10 March 2010

**FP/23/10/T - Application for tree works on two Yew trees at 12 Grafton Avenue Felpham.**

ARUN DISTRICT COUNCIL				
No.	FP	23	10	T

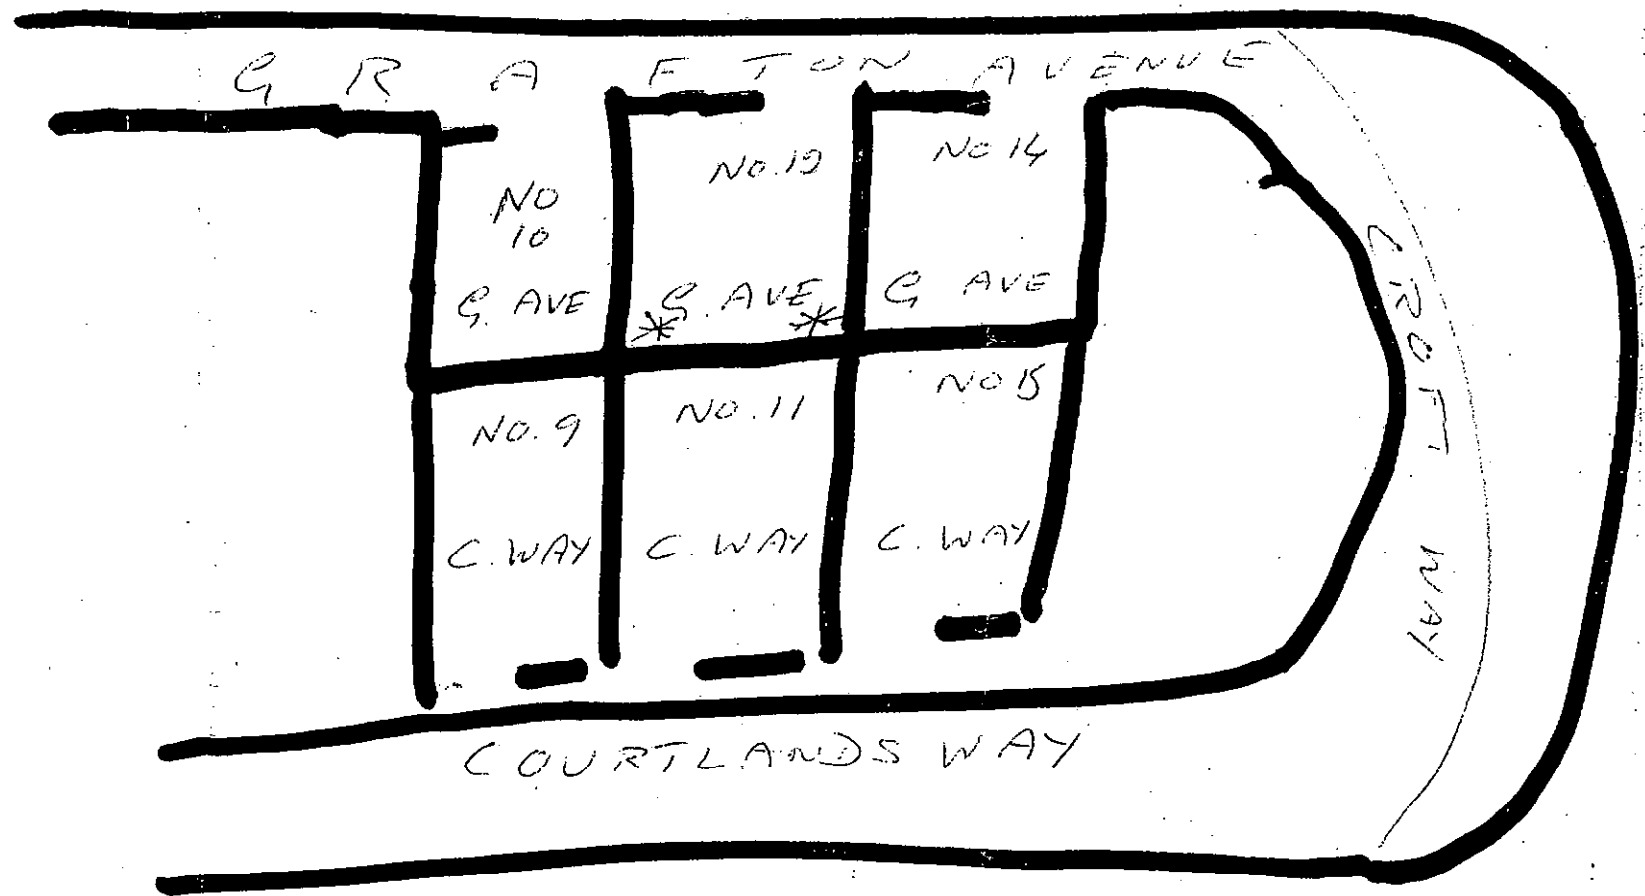
I have today had a look at these two trees and I consider them to be of significant value, even though they are situated in the back garden of number 12. The TPO was placed on them in 1962.

Application refers to various nuisances caused by these two trees, firstly in the shedding of the Yew berries (the red part of which are NOT poisonous), and the fact that the trees are overshadowing sheds, greenhouse, and other fixtures in adjacent property.

These reasons are not sufficient to prune these trees back to the edge of the property as suggested in the submission, and I would recommend that a light reduction overall of 15% would be acceptable.
